Application No: AB/50/21/L
Site Address: Old Bank House 1 High Street Arundel BN18 9AD
Description of works: Listed building consent for the replacement of all windows with new timber double glazed sliding box sash windows and the proposed rendering of the South Elevation (front) and the West Elevation (side) with render painted white.

Thank you for your internet representation made on 16th May 2021 which has been recorded as an objection with the comments as follows:

Existing external walls brickwork (previously rendered). South elevation (front) and West elevation (Side) to be rendered and painted white

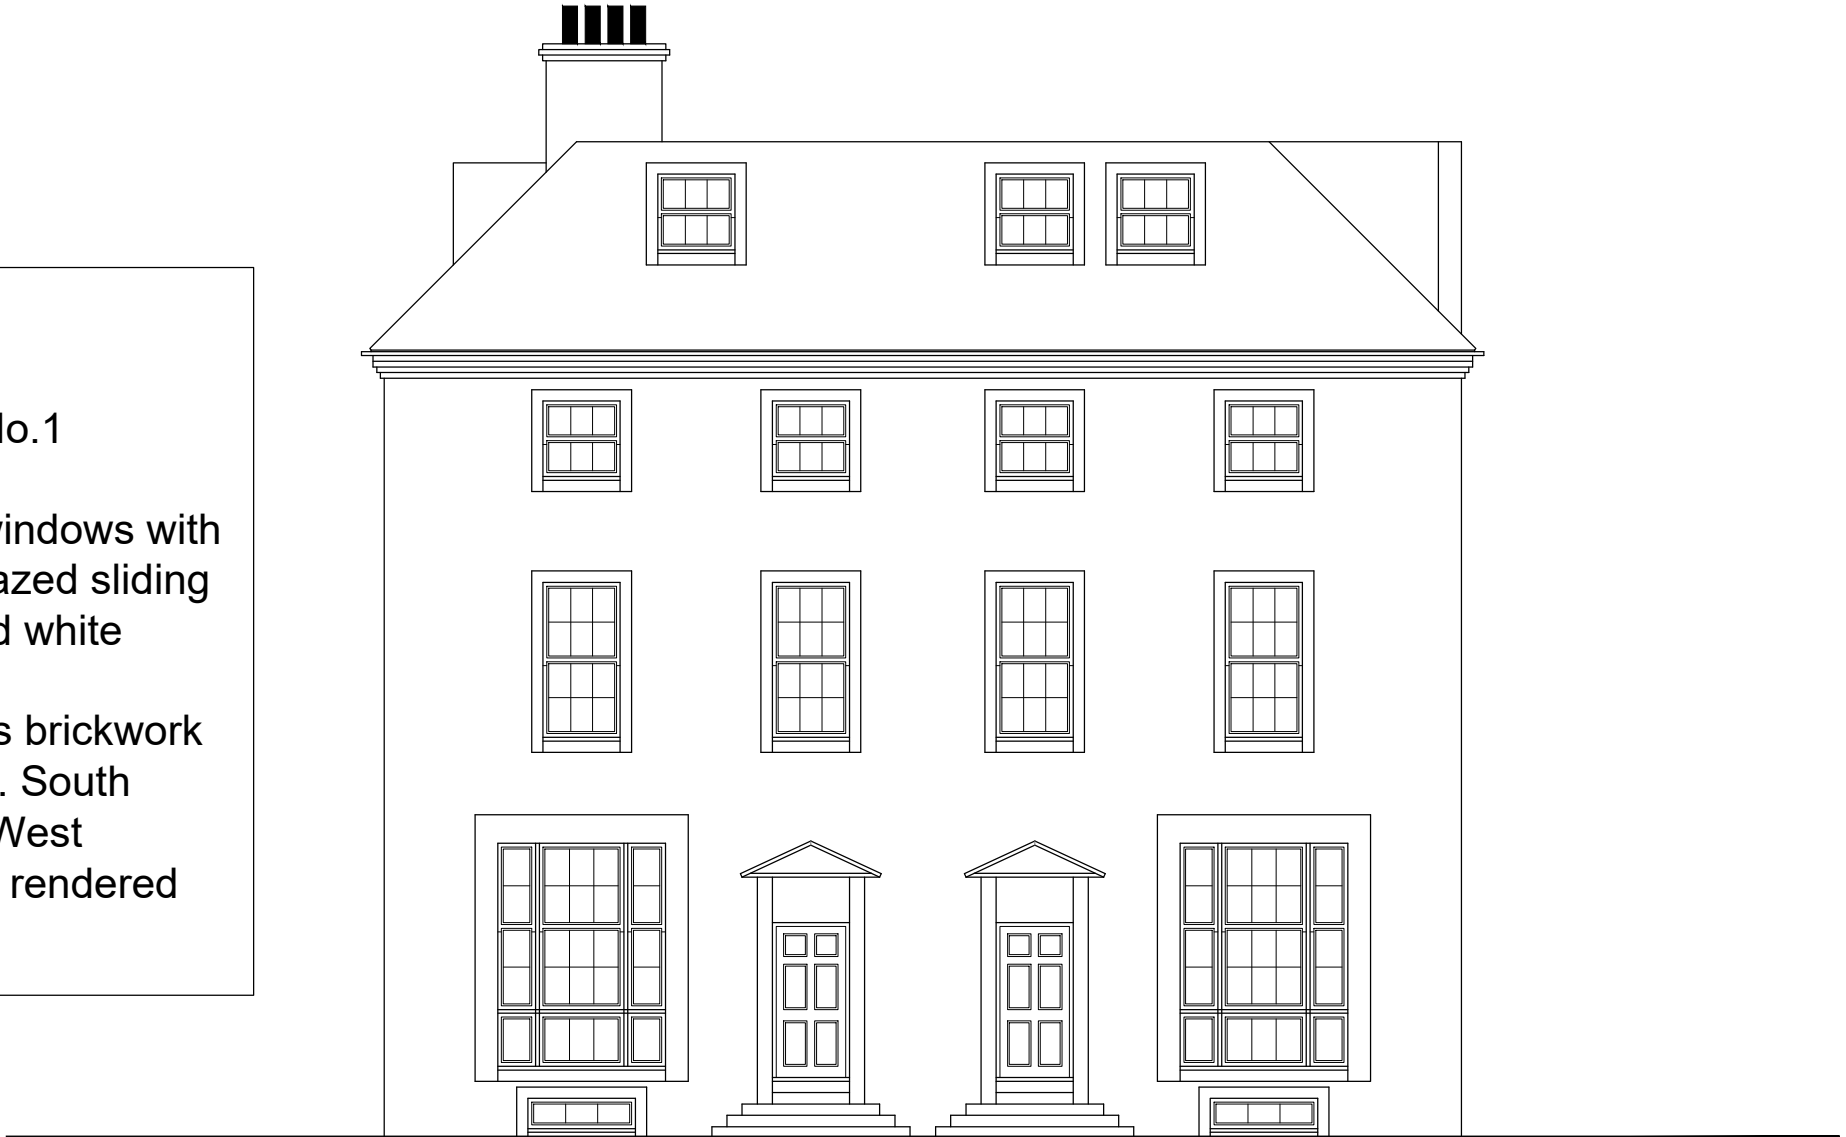
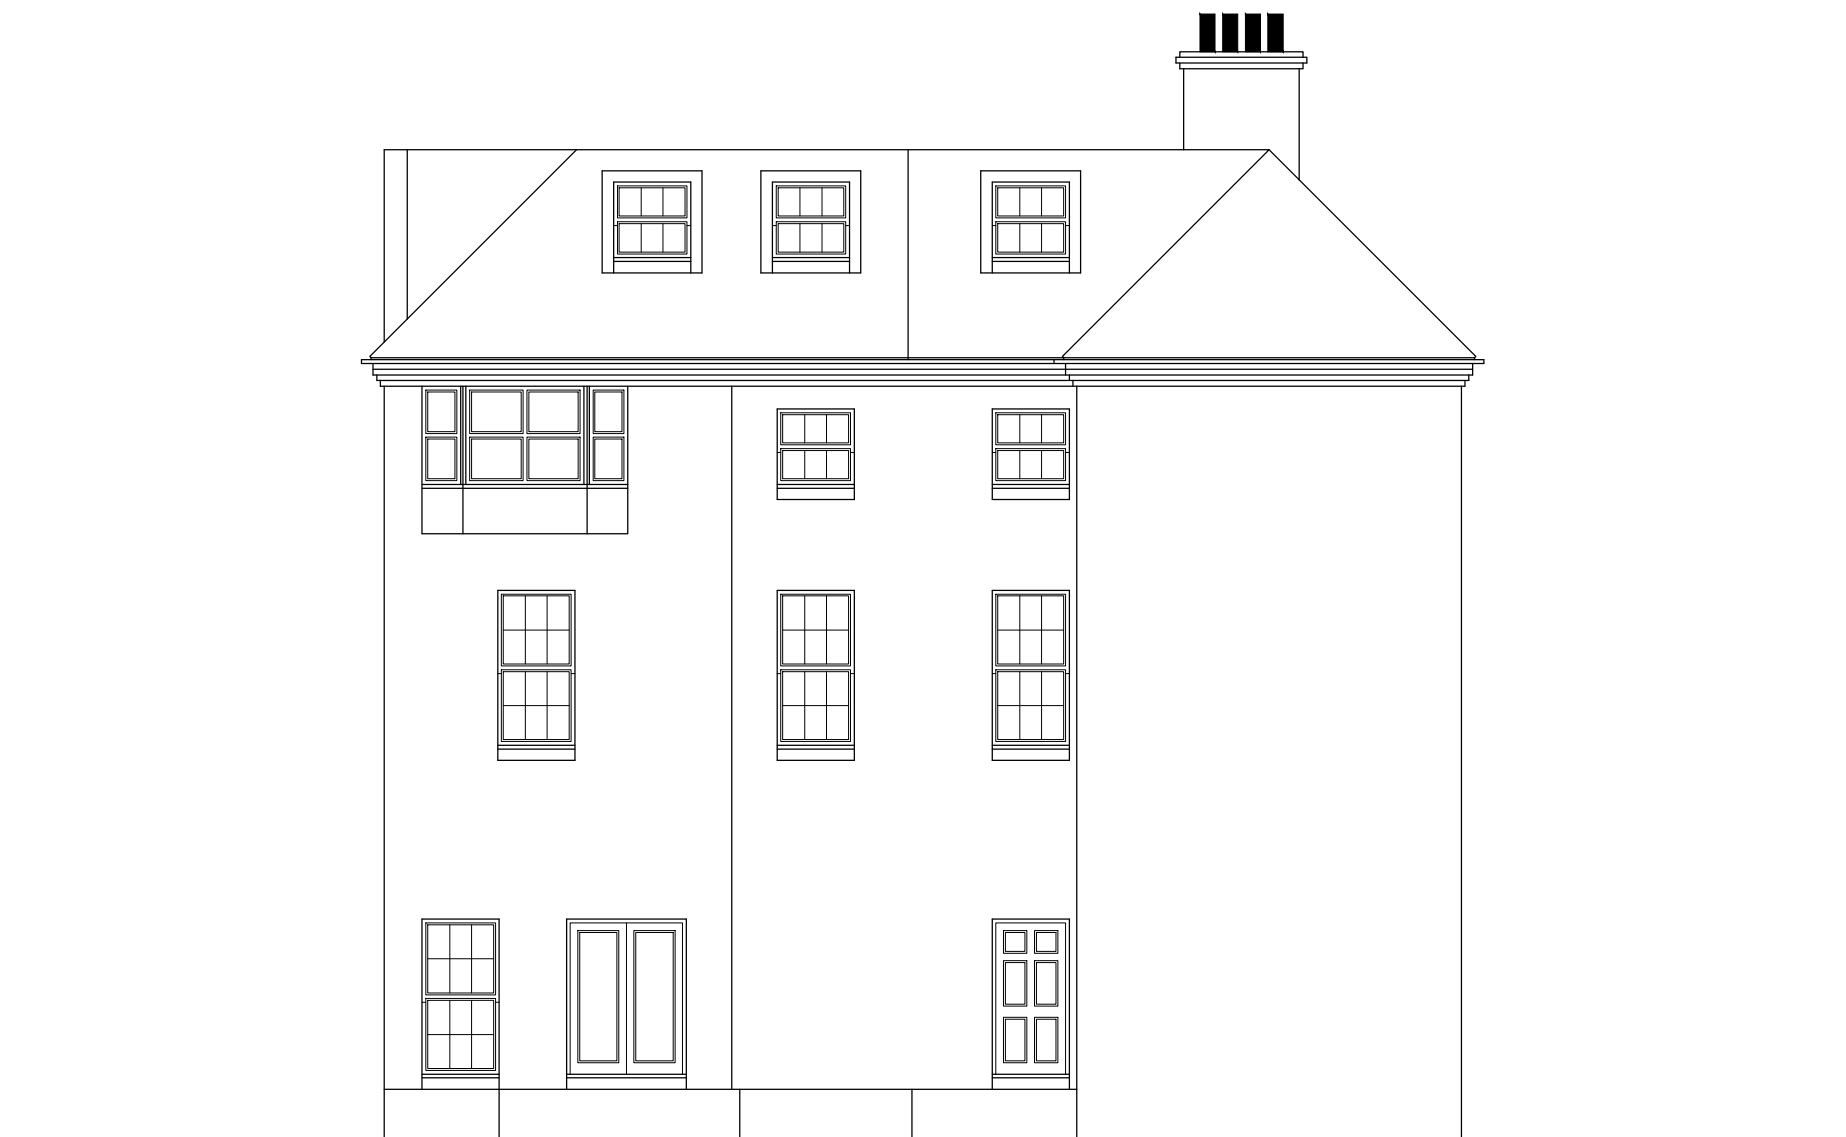
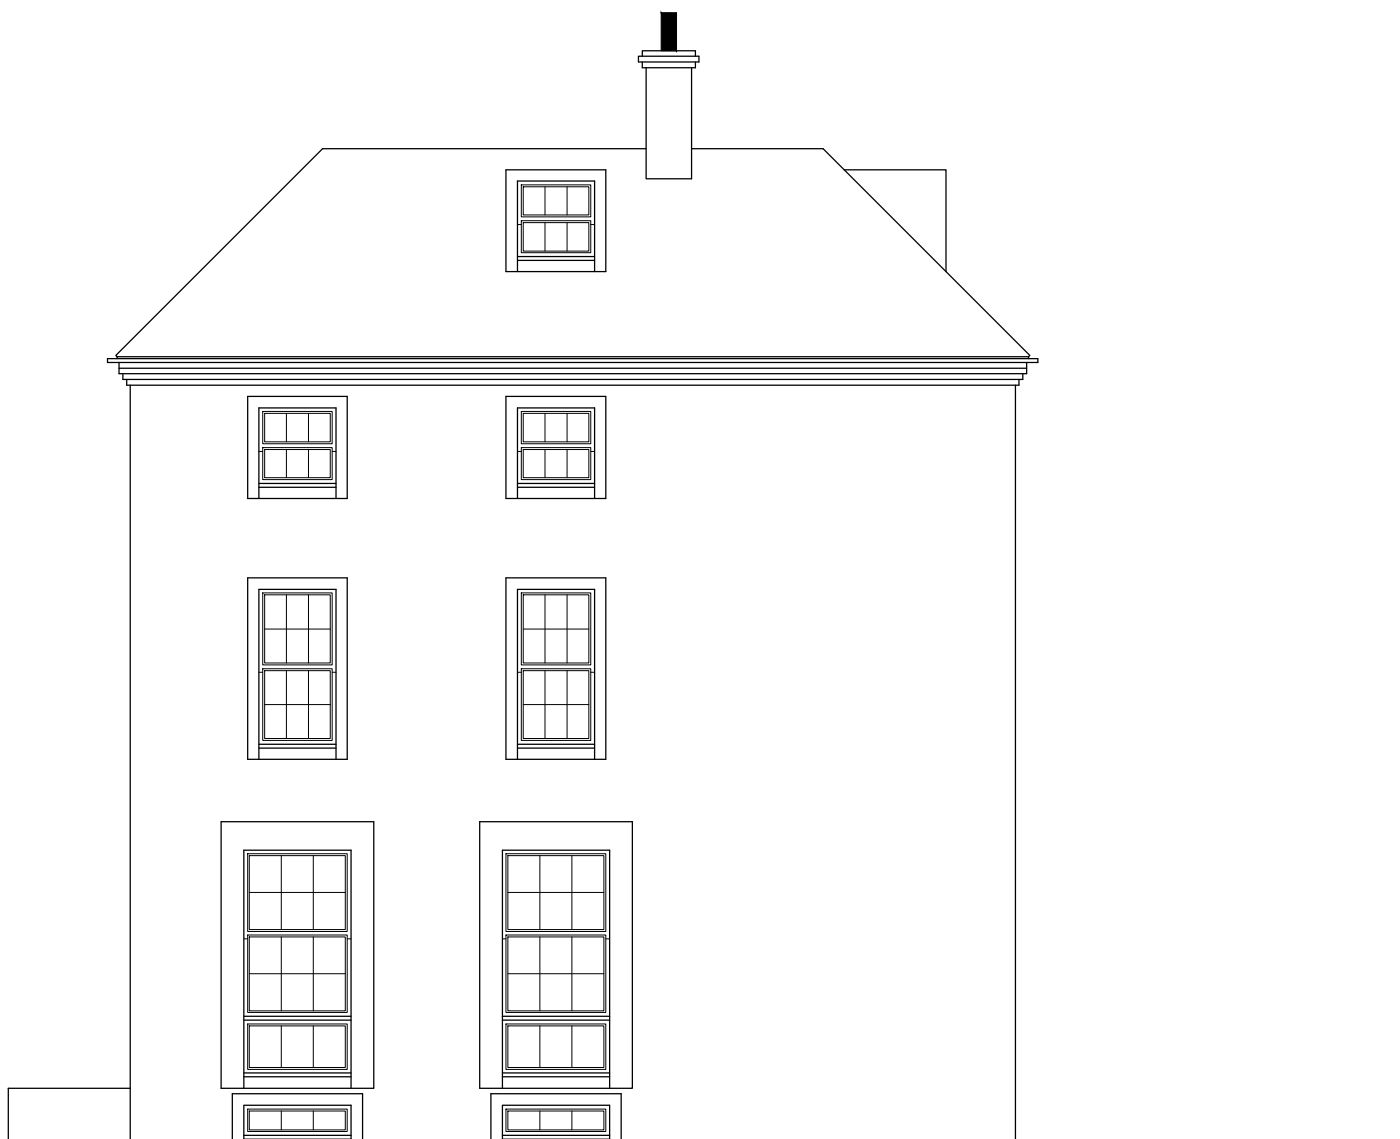
In respect of the proposal to render the south and west elevations of the building it is true that the building did have stuccoed facades (mentioned in the listing description) and this must have been removed shortly after or at the time of its listing in 1974. If the Council consider it acceptable to render the facades, then it needs to be undertaken in accordance with best historic building practice. A comprehensive and acceptable method statement is required which should include details such as mortar mixture, method of application and finish, depth, and how details such as the existing brick dentil course at eaves level and the lead flashing around the hood of the doorcase will be treated or accommodated.
